KITTITAS COUNTY COMMUNITY DEVELOPMENT SERVICES

RE: Strange Road Short Plat (SP-08-00016)

The Kittitas County Community Development Services Department has determined that the Strange Road Short Plat (SP-08-00016) is a complete application and hereby grants **conditional preliminary approval** subject to the following conditions:

STRANGE ROAD SHORT PLAT
 PART OF SECTION 6, T. 17 N., R. 19 E., W.M.
 KITTITAS COUNTY, WASHINGTON

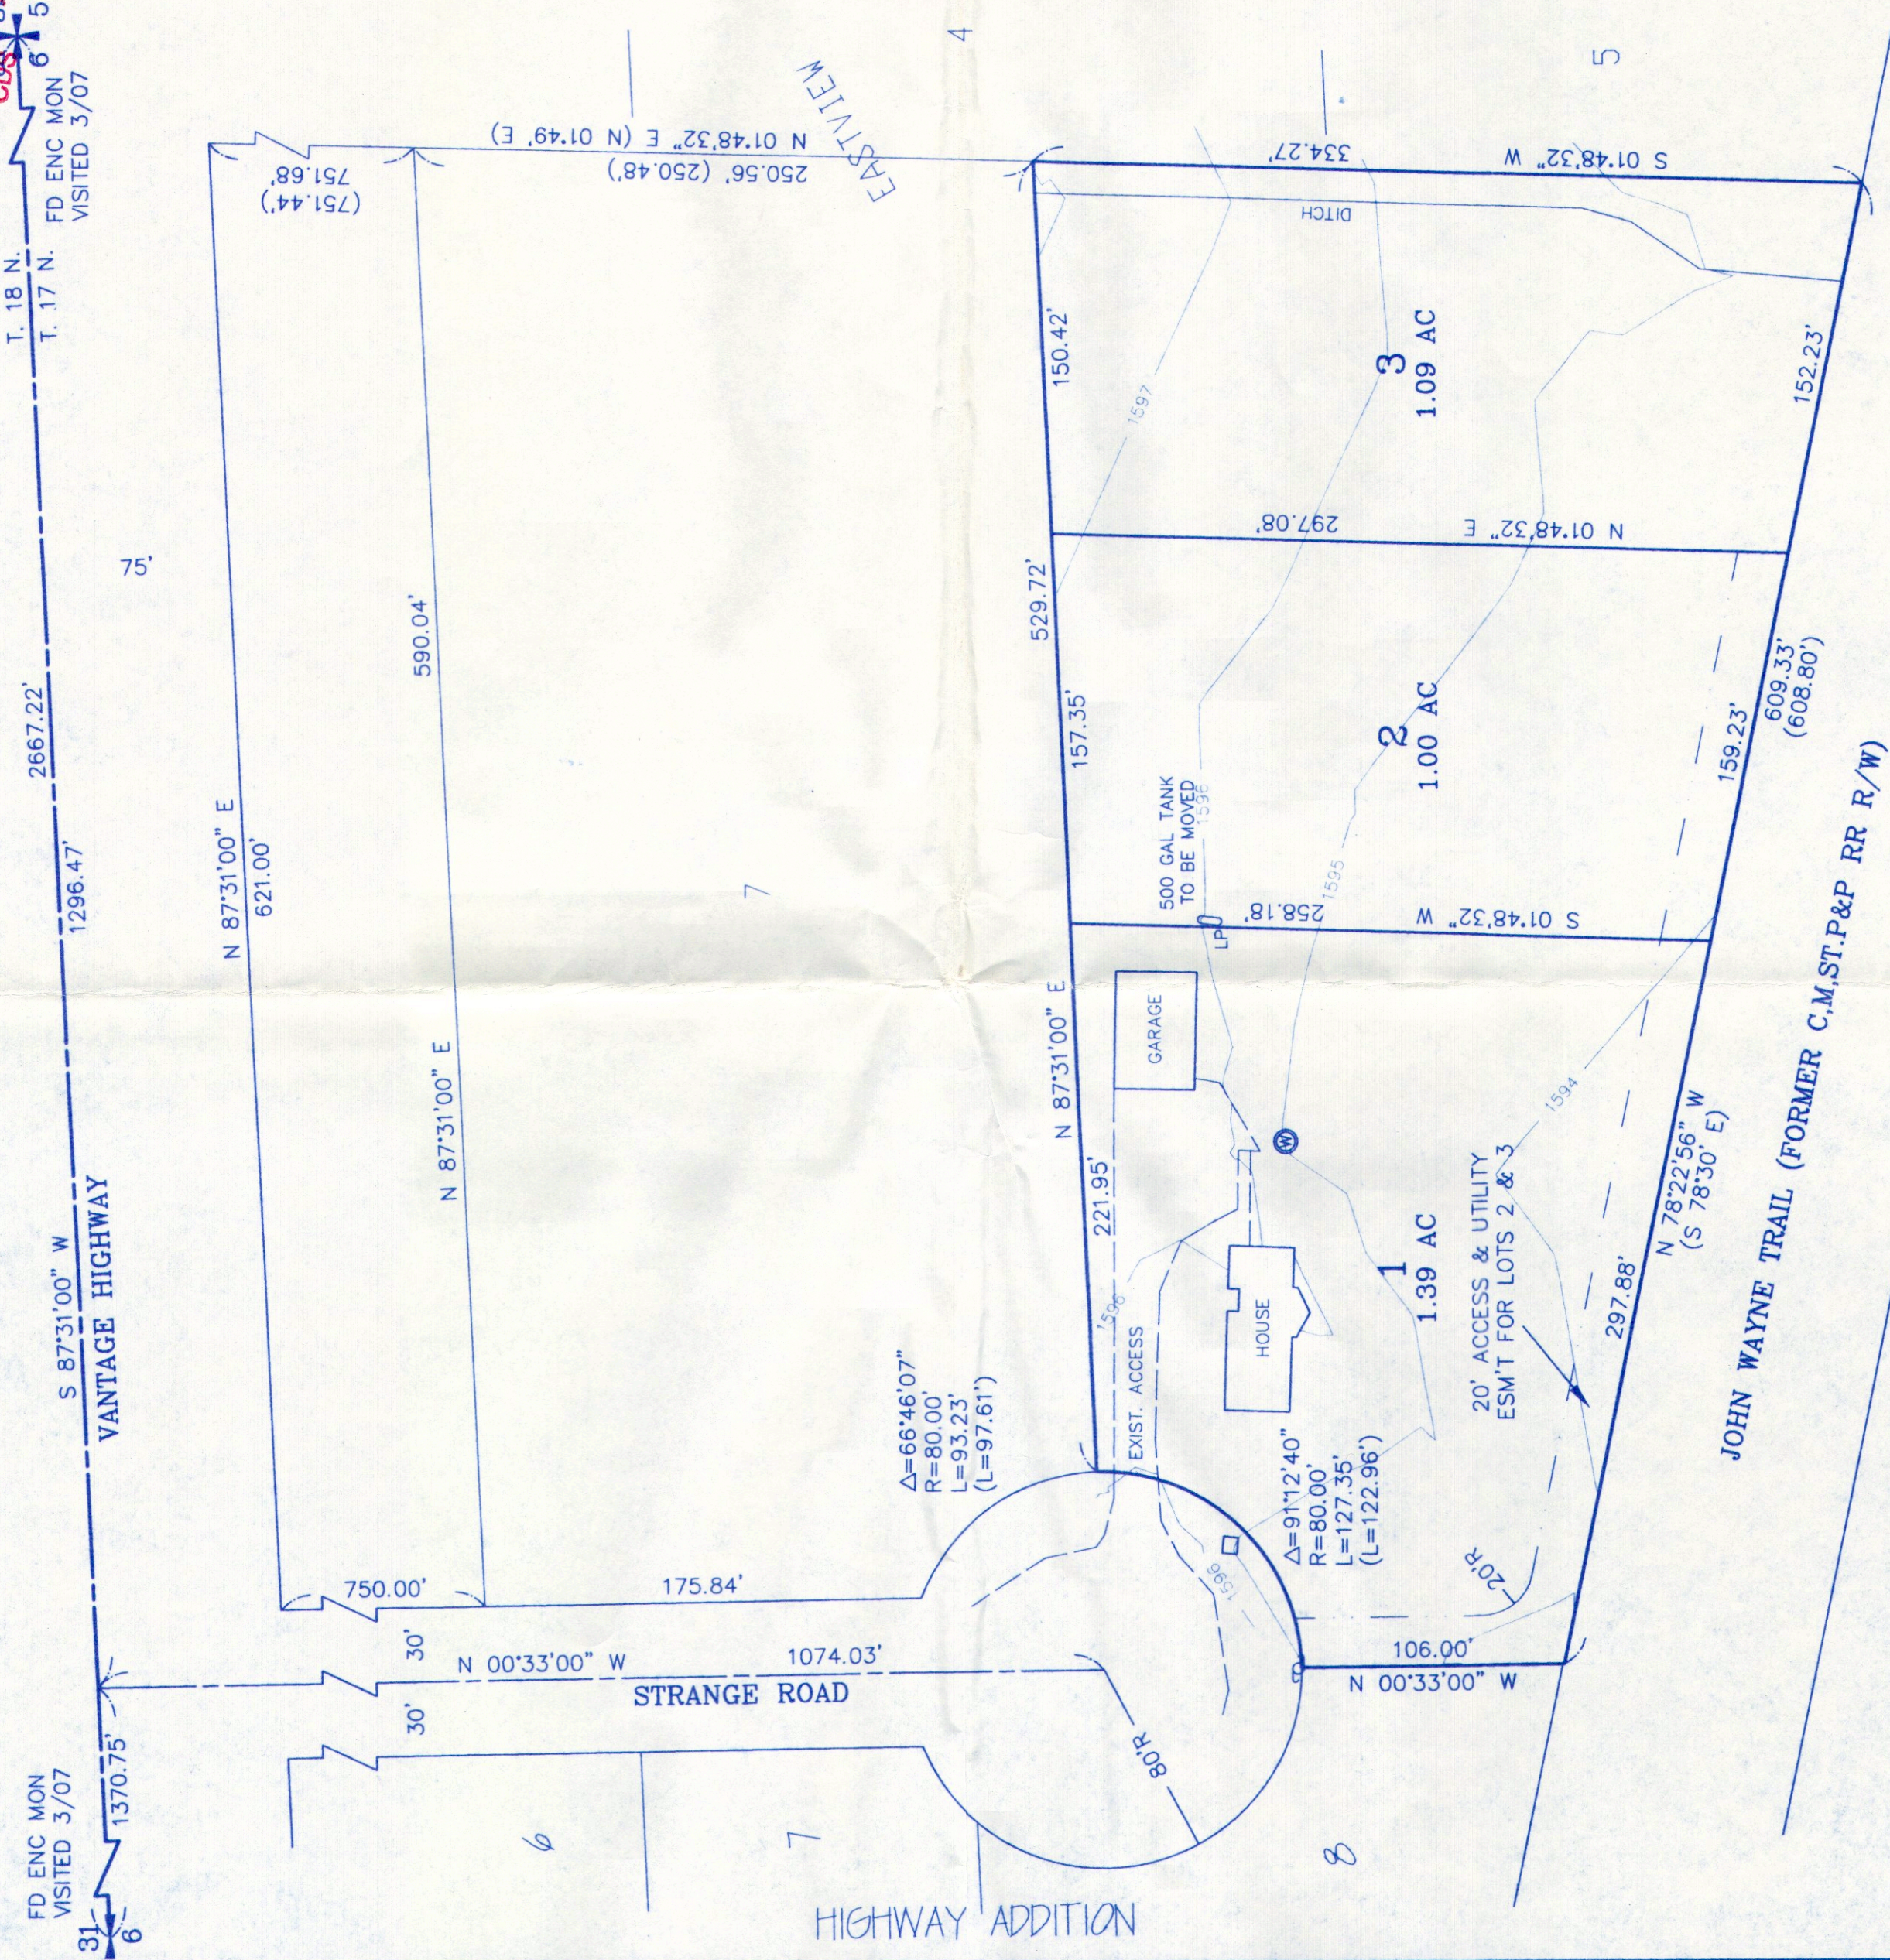
2. Full year's taxes must be paid on all tax parcel numbers per requirement of the Kittitas County Treasurer's Office.
3. The existing 500 gallon tank located on Lot 2 of the preliminary drawing shall be moved to Lot 1, to a location meeting all setback requirements. The applicant shall acquire appropriate permits prior to final approval and the new location shall be shown on the final mylars.
